Re: PA22-042 – Sunnyside Village Co-Housing – Technical Review 2
3121 66th Ave NE – APN: 29050300402100

After preliminary review of the above referenced proposal, the Planning Division has the following comment(s):

RE: Sunnyside Village Co-Housing, File# PA22-042
32 – lot cottage housing development
3121 66th Ae NE & Parcel # 29050300402100

C-2

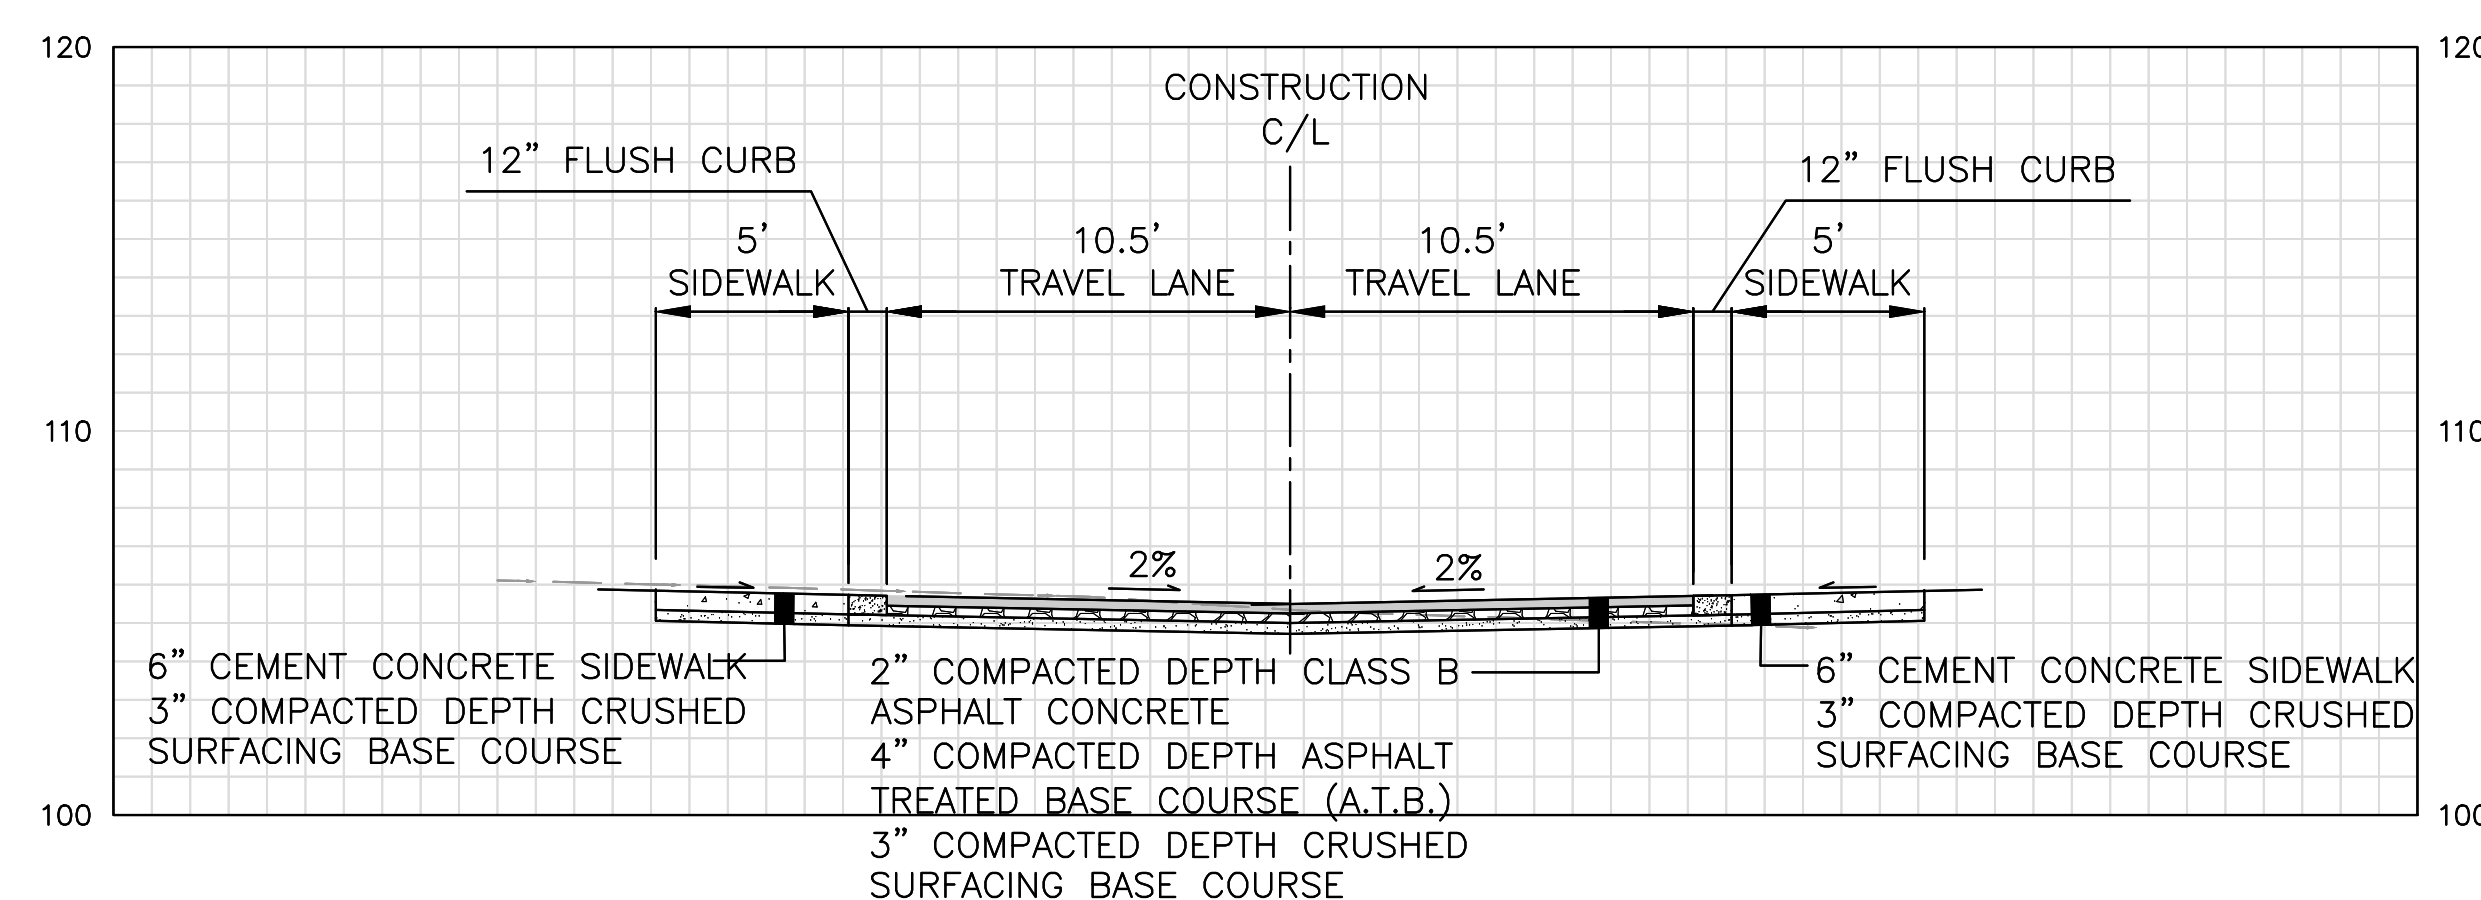
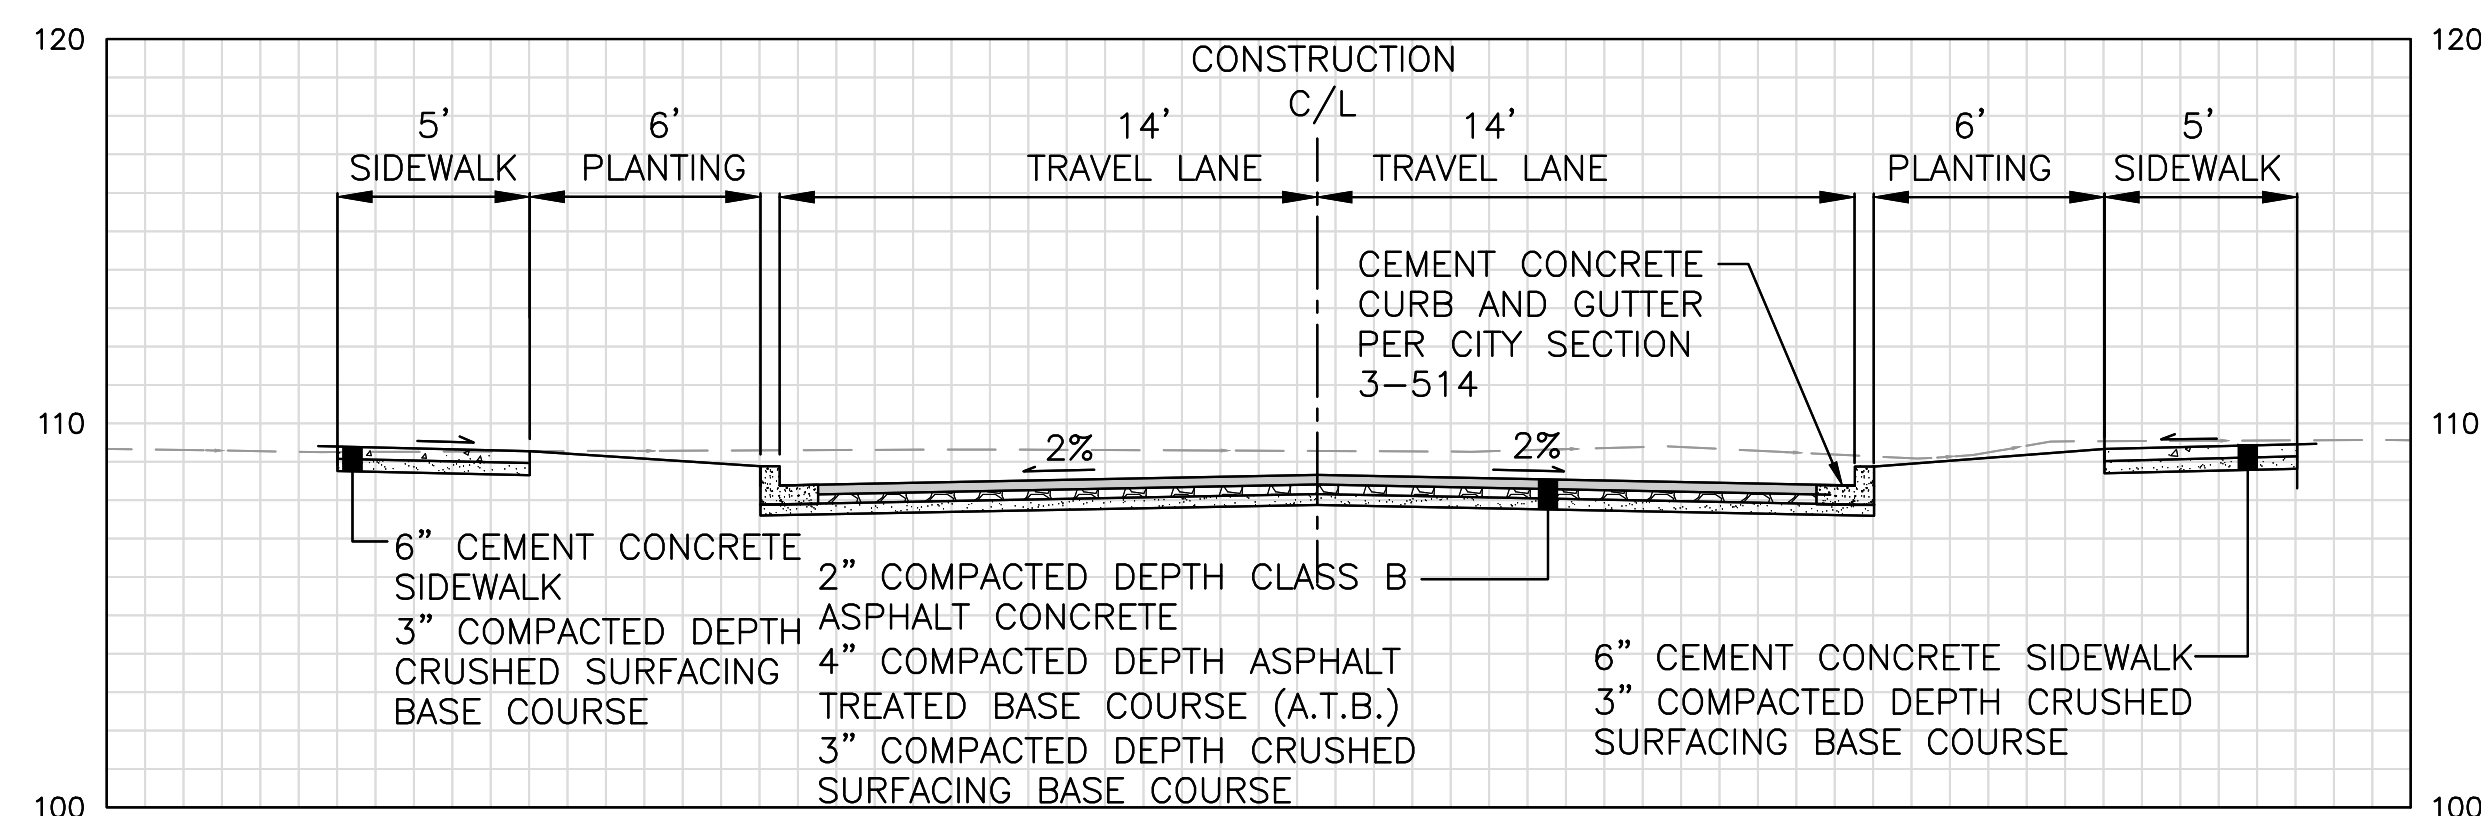
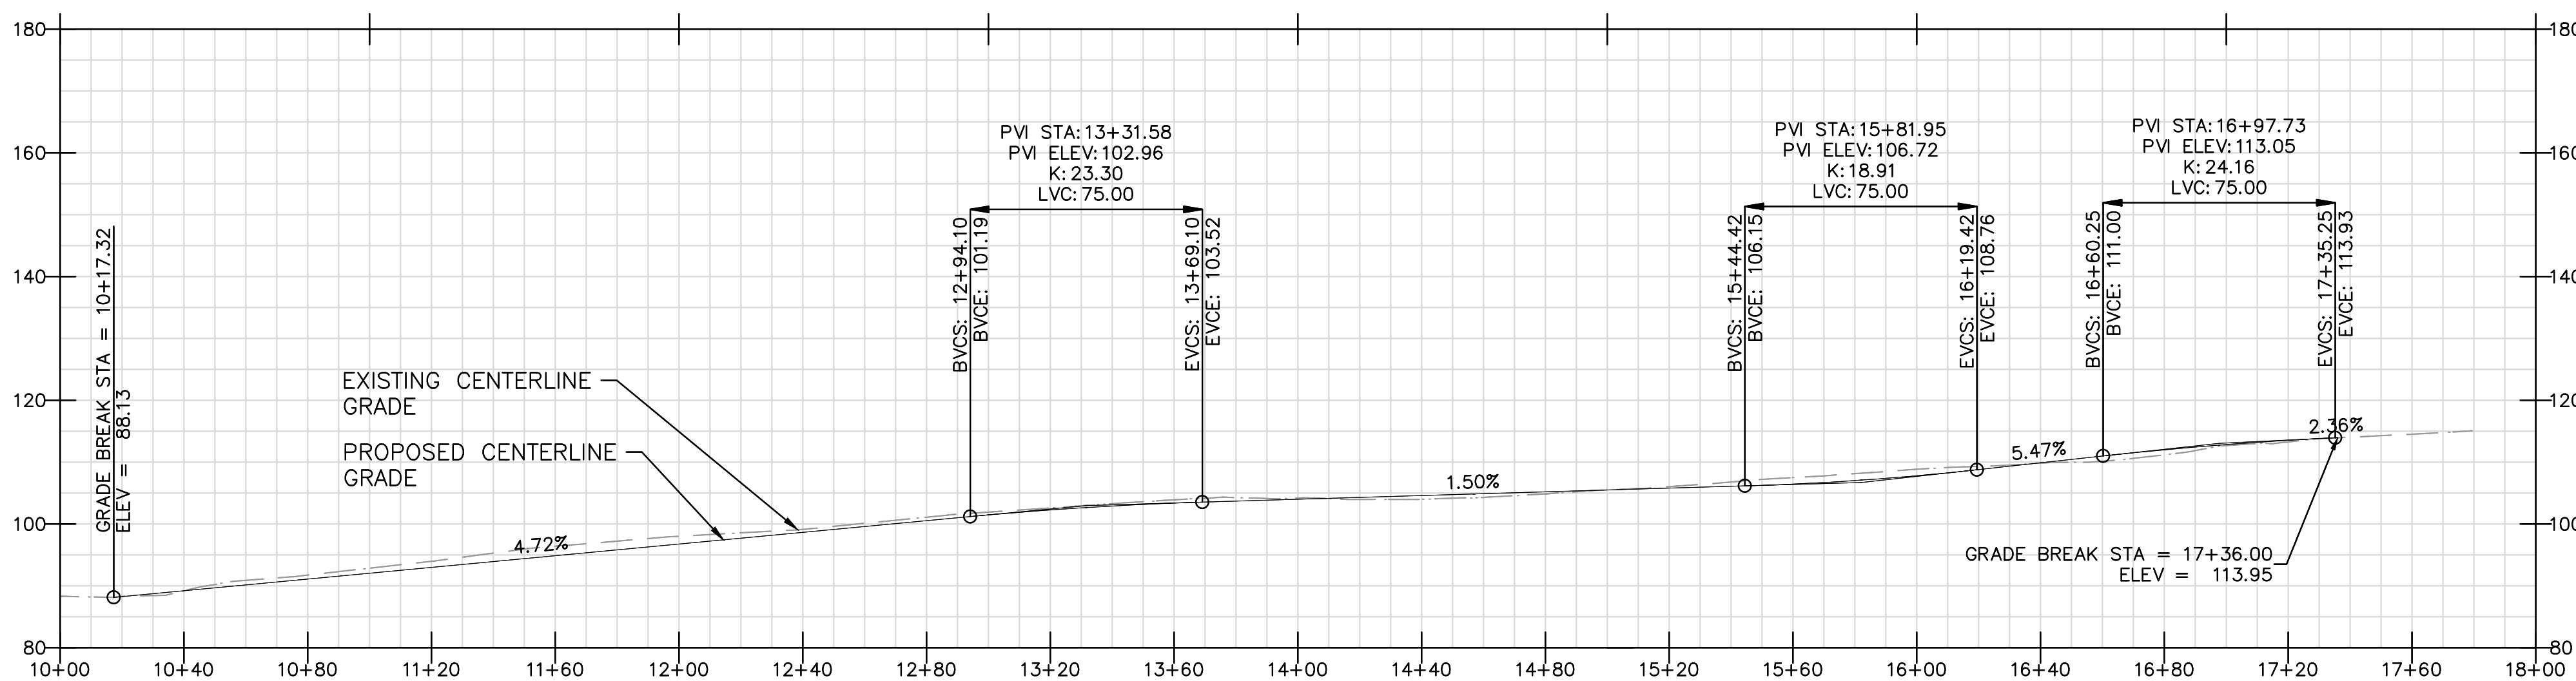
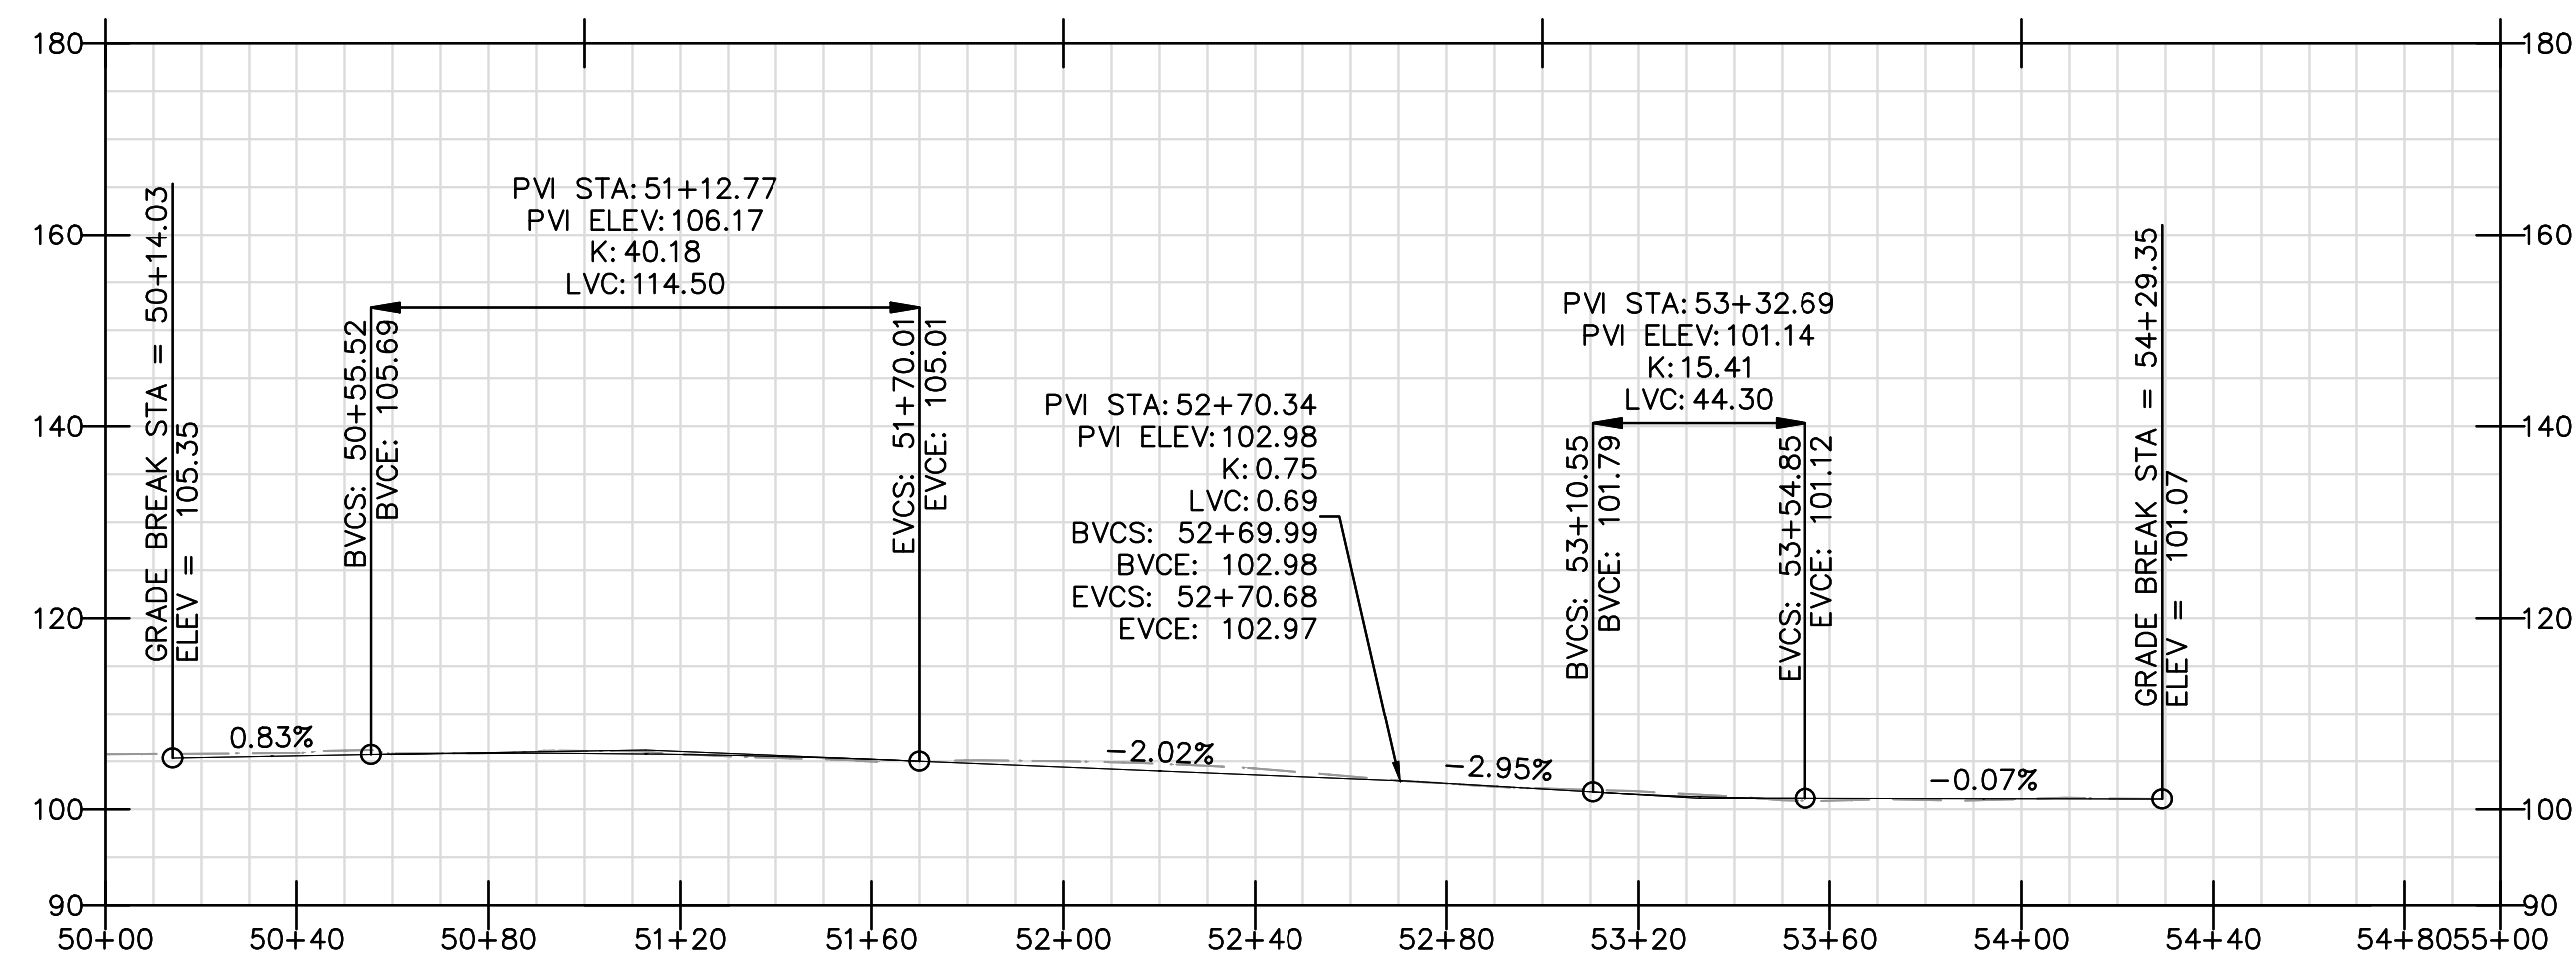
- a. 66th Ave NE is classified as a local access street and is to be built compliant with SP 3-202-002 of the EDDS.
4. **Dedication Requirements:**
 - a. The extension of 66th Ave. NE requires a 50 foot dedication, which is currently shown on the supplied documents.

5. **Access:**
 - a. The minimum width of a multi-family driveway is 20-feet and the maximum is 30-feet.
 - b. The private drive aisle is to have 22 feet of pavement width, then the gutter and rolled curb.
